CITY OF ALBUQUERQUE

**Re: Stormcloud Subdivision Unit 5
Erosion and Sediment Control Plan
Engineer's Stamp Date 4-27-15 (C18E012)
H09E022**

Based upon the information provided in your submittal received 4-30-15 the above referenced plan is not approved to be included in the SWPPP and for Grading Permit until the following comments are addressed:

### Stormcloud Subdivision, Unit 5

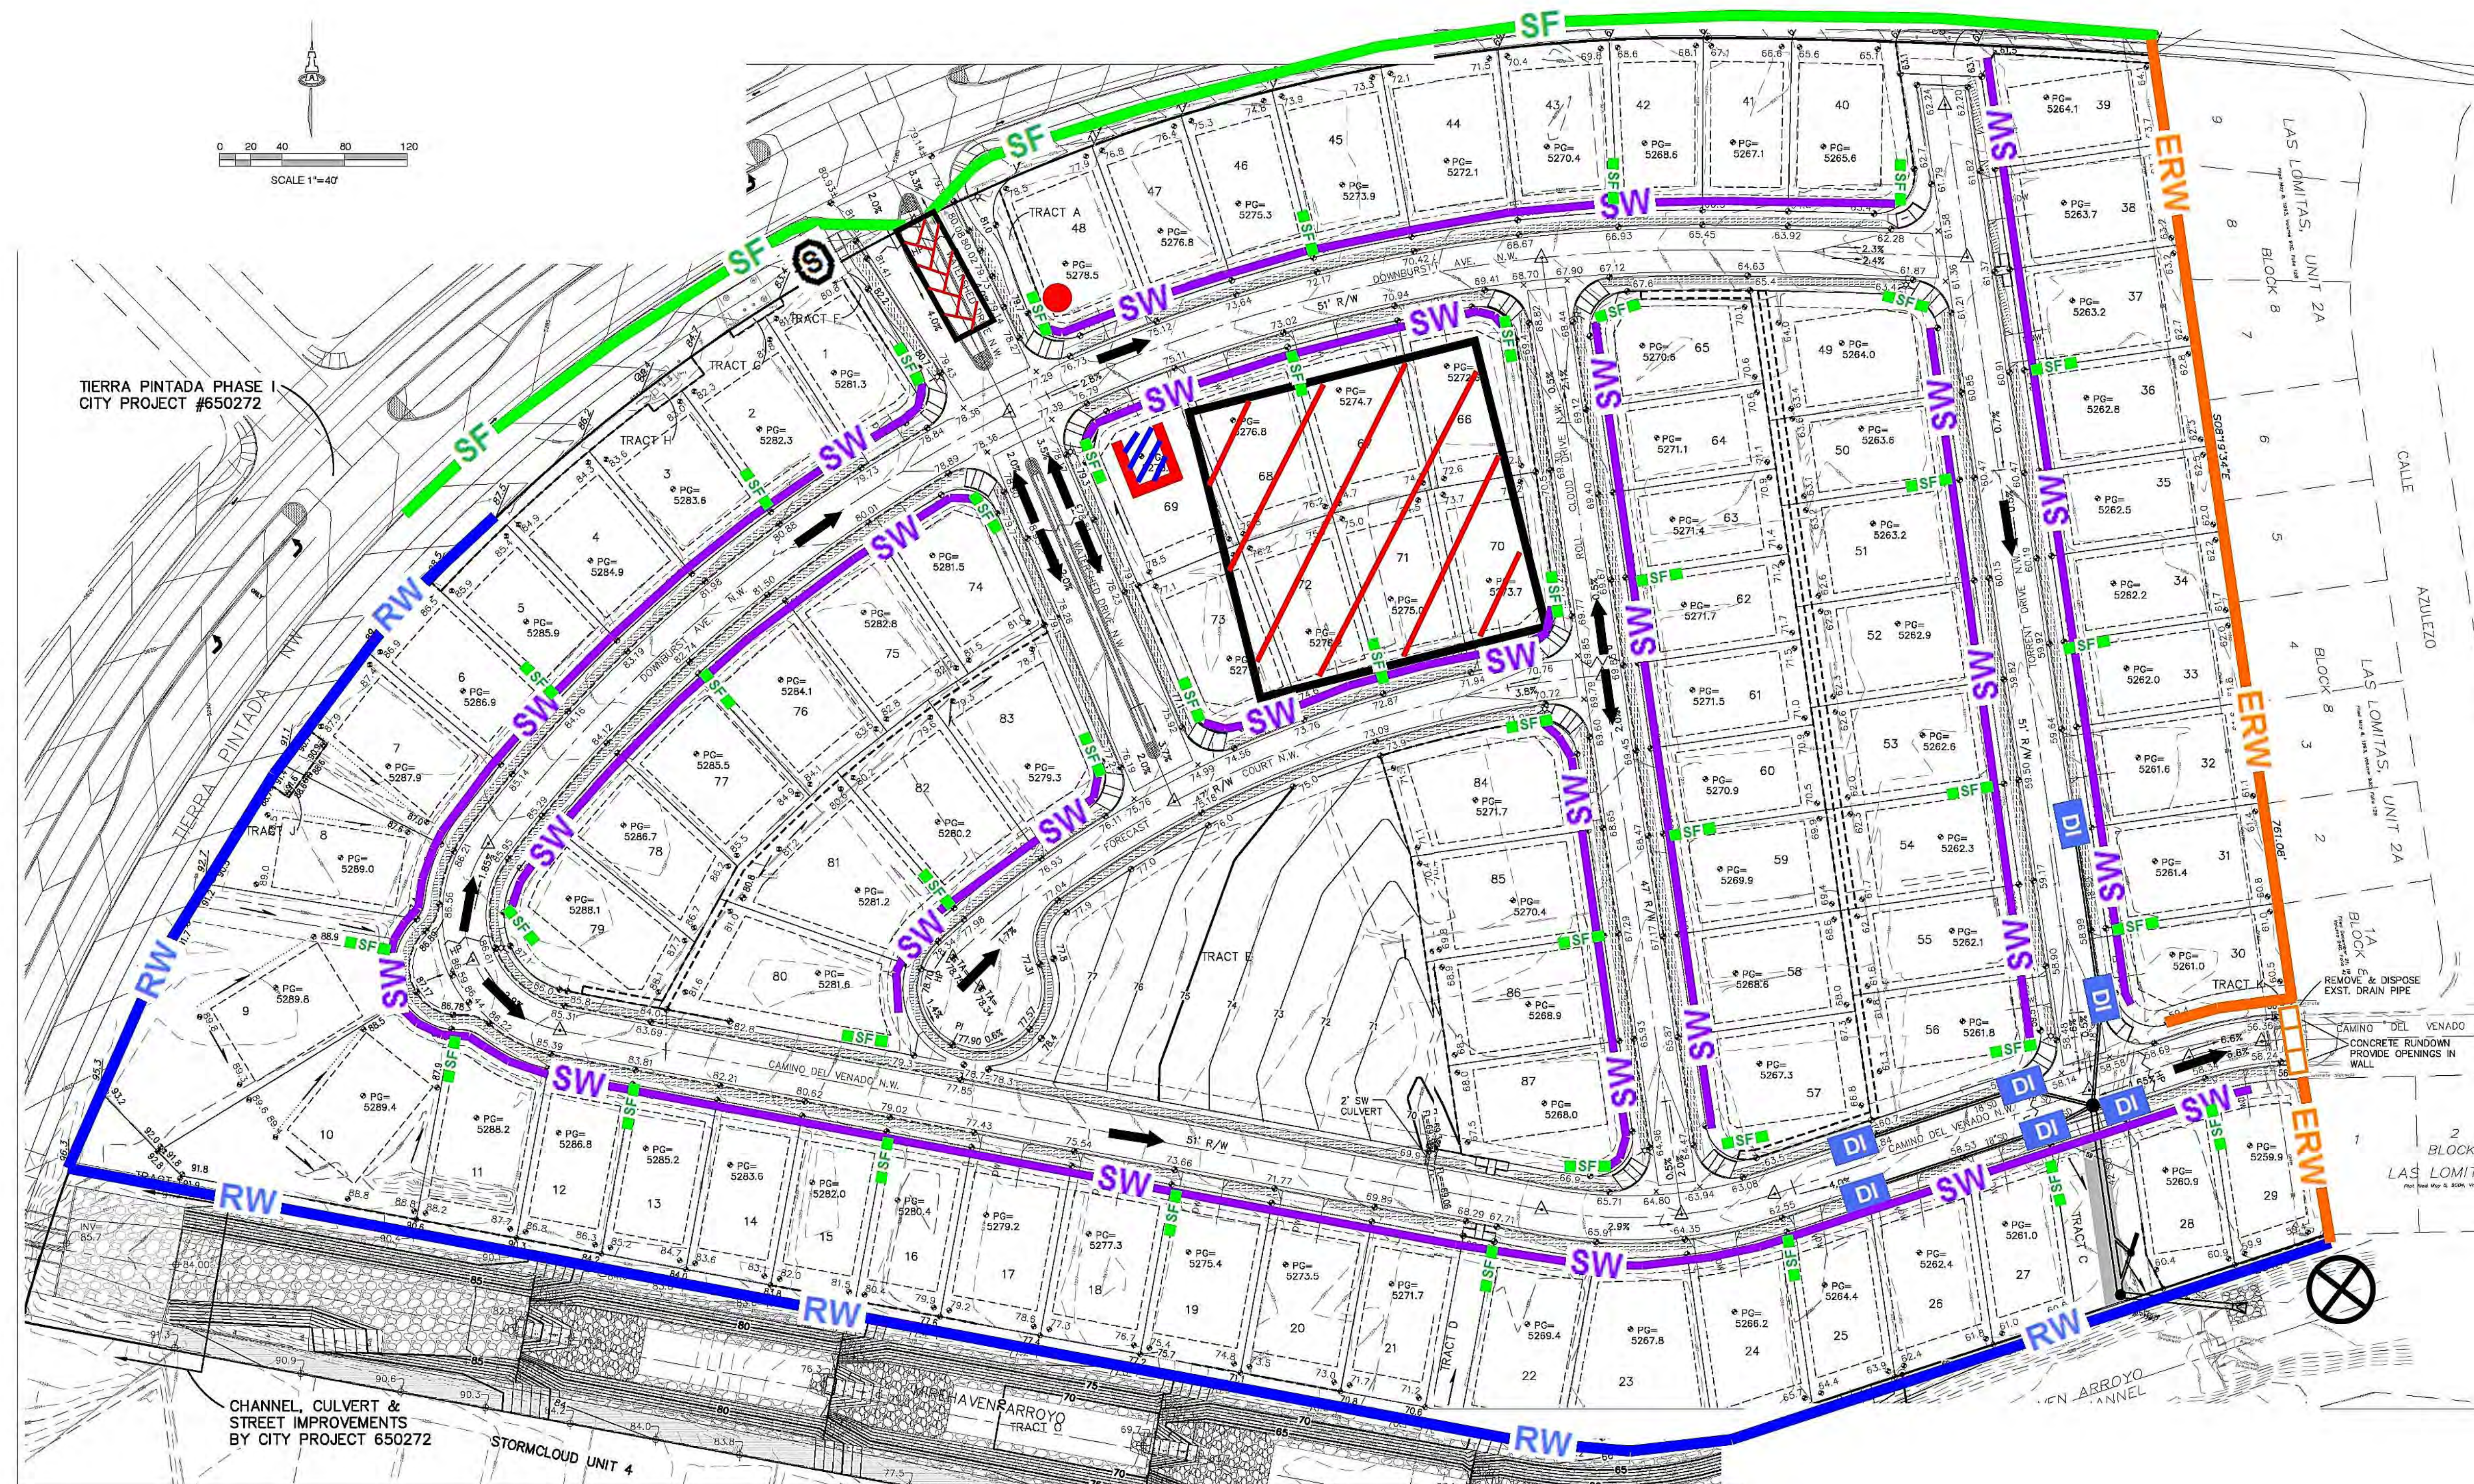
1. In the "swale behind curb.." area a silt fence extending from the back of curb about 15 feet or so every third lot where the street slope is transverse to the lot grade should prevent sediment from travelling behind the back of curb and depositing in the street at the bottom of the hill.

I got this idea from Pulte Homes at Mirehaven and Twilight homes at Valle Vista at The Trails. I think it will help at all residential subdivisions.

2. Please add to the "-RW-" keyed note "...install silt fence if retaining wall is down for more than one week". The arroyo is close.
